City of Albuquerque Stormwater Construction Site Inspection Report

ESC File No.	M15E021C	Project Name:	Dutch Bros. NM0303
NPDES Id. No.	NMR1005GM	Location:	2131 Gibson Blvd SE
9/28/2023	Owner	Contractor	
Operator	Dutch Bros, LLC		
Contact name & title	Daniel Batty		
e-mail	daniel.batty@dutchbros.com		
Contact Phone #	541-955-4700		
COA Inspector	Chancellor English	Start/End Time:	1230pm
Construction Phase:	Excavation, utilities		
Type of Inspection:	Regular	Storm Event	Post Storm Event >0.25"
		311/Complaint	Follow Up
Weather at time of inspection?		Clear	Temperature: ~ 85
Estimated date of last storm 0.25" or greater		9/13/2023

Title:  
EROSION AND SEDIMENT CONTROL PLAN  
SWC GIBSON BLVD AND YALE BLVD  
ALBUQUERQUE, NM 87121

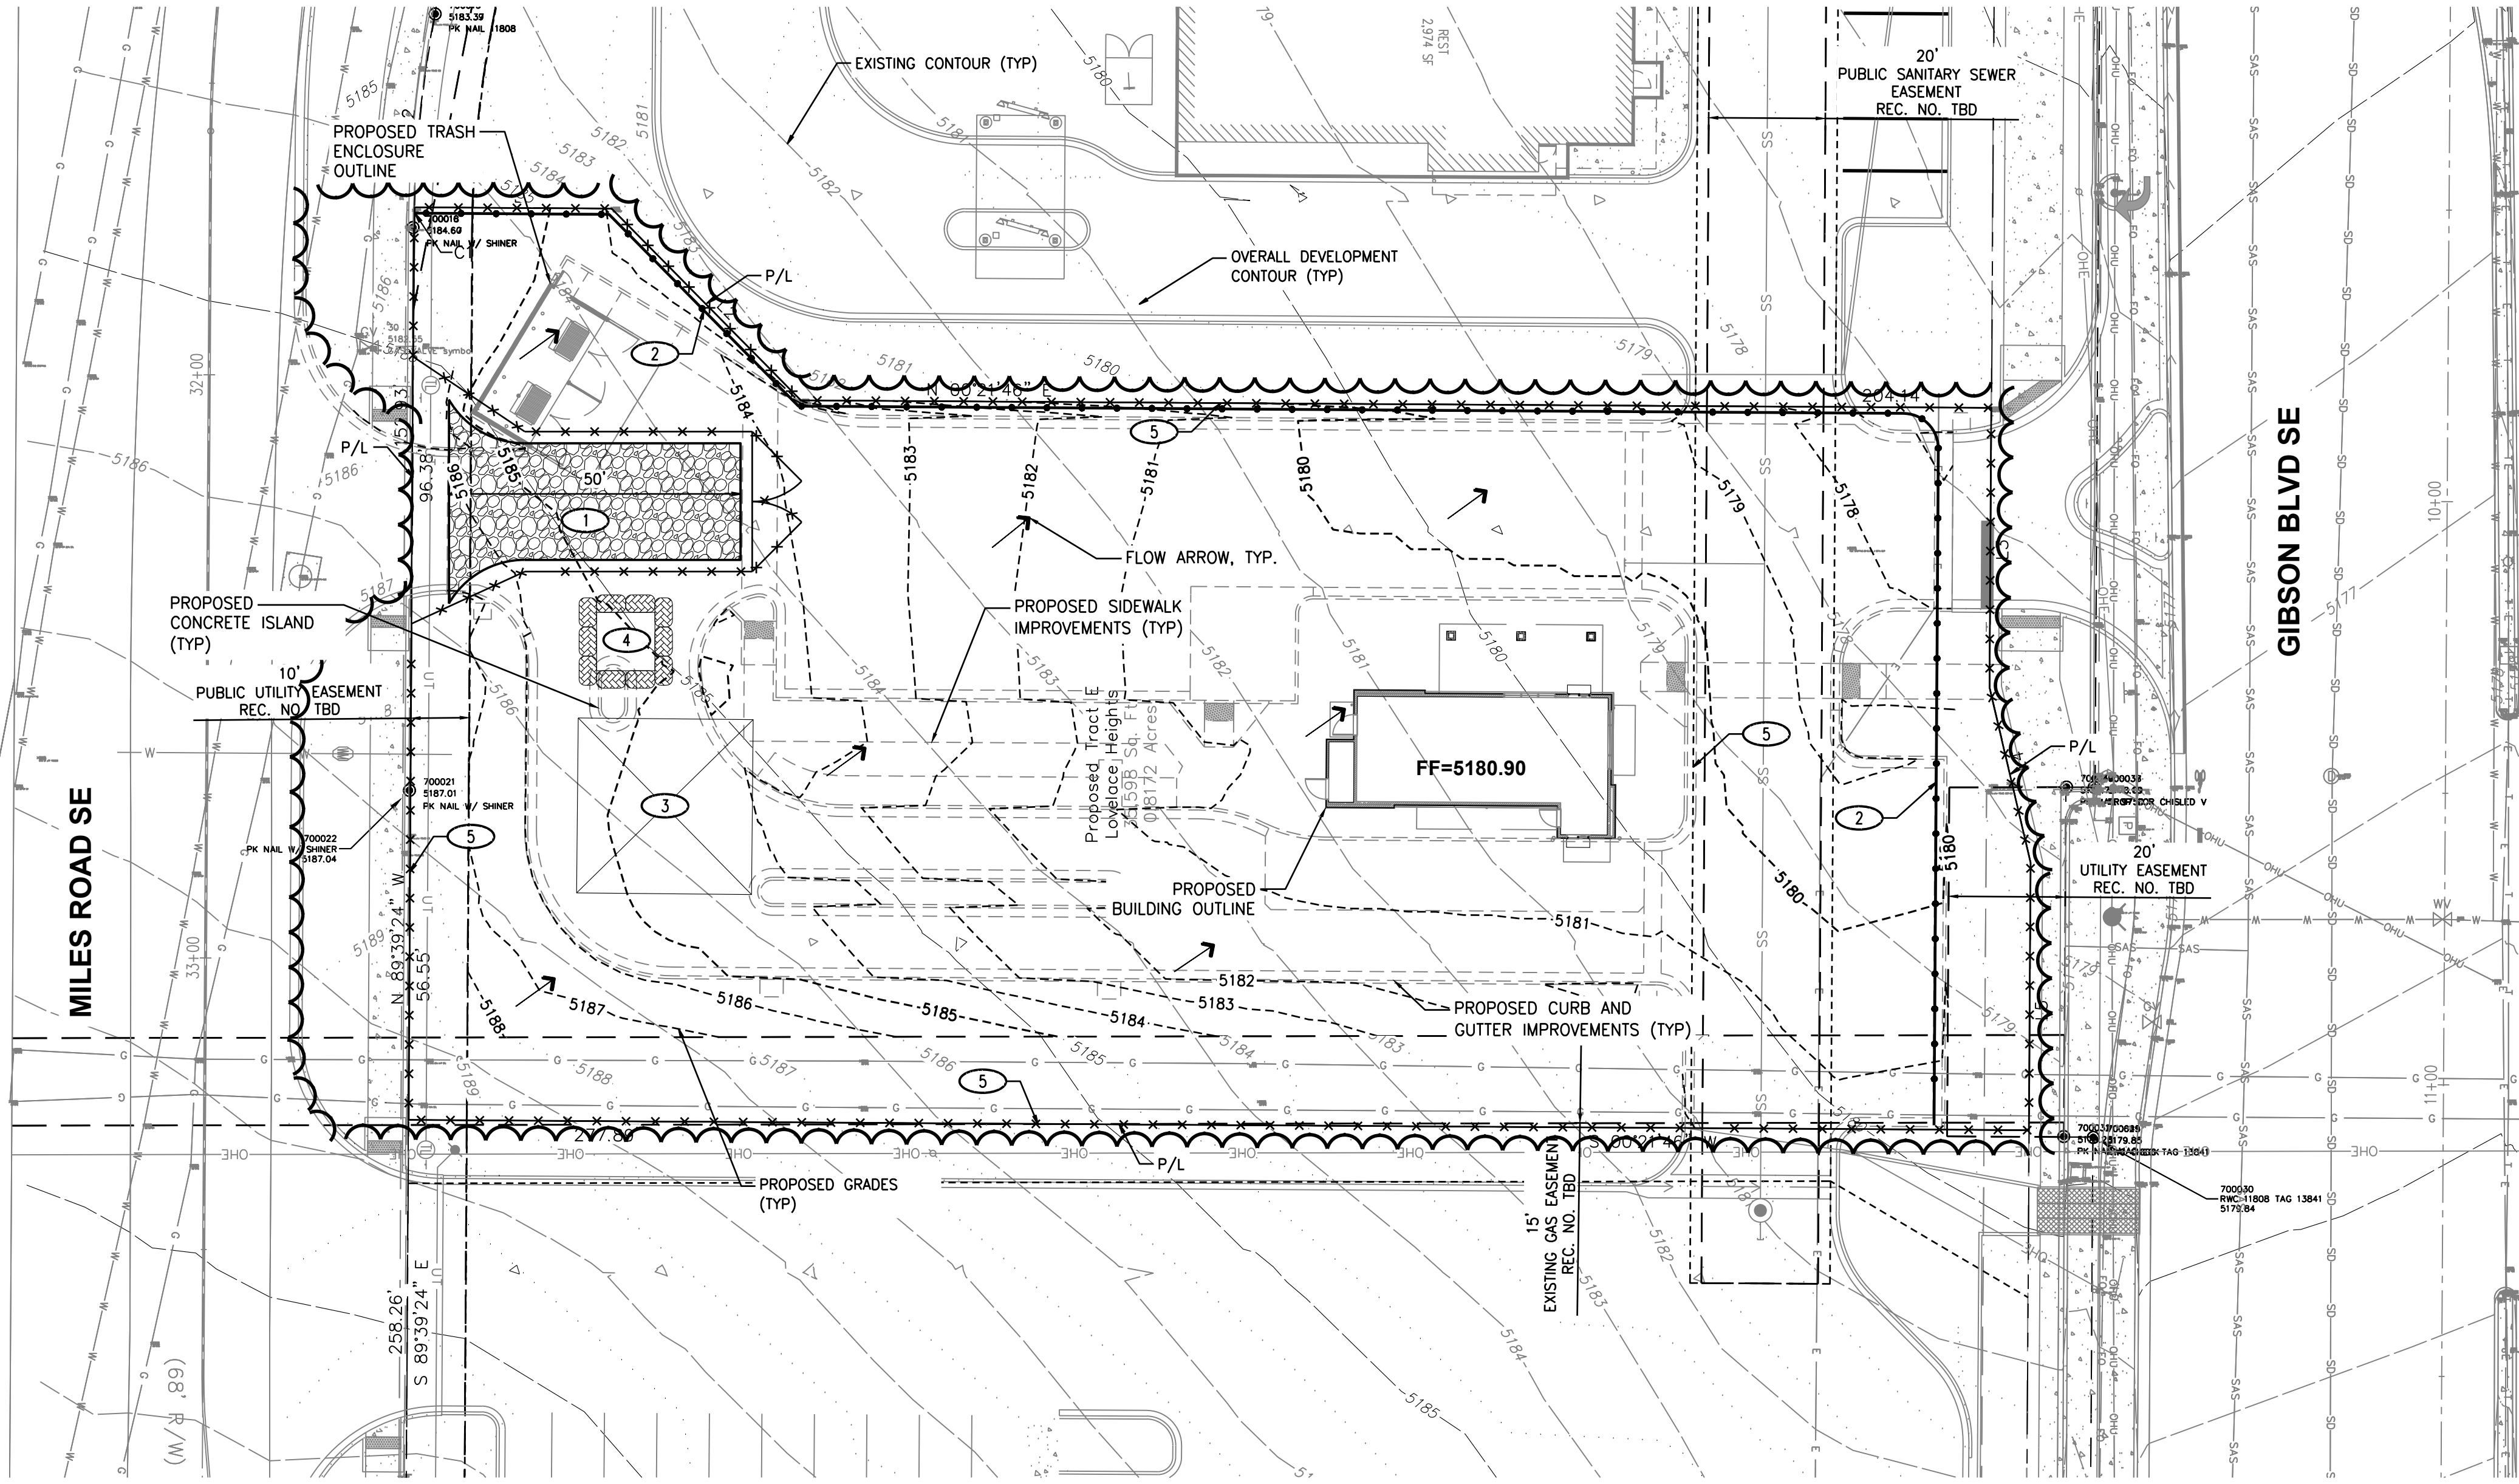
3	The perimeter silt fence needs maintenance and repair. There is land disturbance beyond the installed silt fence in violation of CGP Parts 2.1.3 and 2.2.3 and the silt fence has been inundated to the point of sediment discharge in violation of CGP Part 2.1.4. Required mitigation: You must install sediment controls along any perimeter areas of the site that are downslope from any exposed soil or other disturbed areas per CGP Part 2.2.3. You must complete the installation of stormwater controls by the time each phase of construction activities has begun, per CGP Part 2.1.3. You must also ensure all stormwater controls are maintained and remain in effective operating condition during permit coverage and are protected from activities that would reduce their effectiveness per CGP Part 2.1.4.
4	Sediment discharge was observed leading from the site into the ROW and leading onto Gibson Blvd. These discharges stem from poorly installed or maintained perimeter stormwater controls, in violation of CGP Parts 1.2.1, 2.1.2, and 2.1.4. Required mitigation: CGP Part 1.2.1 authorizes stormwater discharges from construction activity provided that appropriate stormwater controls are designed, installed, and maintained. Both noted sediment discharges occurred due to lack of maintenance and poor design and/or installation. CGP Part 2.1.2 requires the desing and installation of all stormwater controls in accordance with good engineering practices and CGP Part 2.1.4 requires that all stormwater controls are maintained and remain in effective operating procedures.

5	There was concrete washout in an un-lined pit (on bare ground) in violation of CGP Part 2.3.4. Required mitigation: Direct wash water into a leak-proof container or leak-proof and lined pit designed so no overflows can occur due to inadequate sizing or precipitation and do not allow liquid wastess to be disposed of through infiltration or to otherwise be disposed of on the ground per CGP Part 2.3.4.
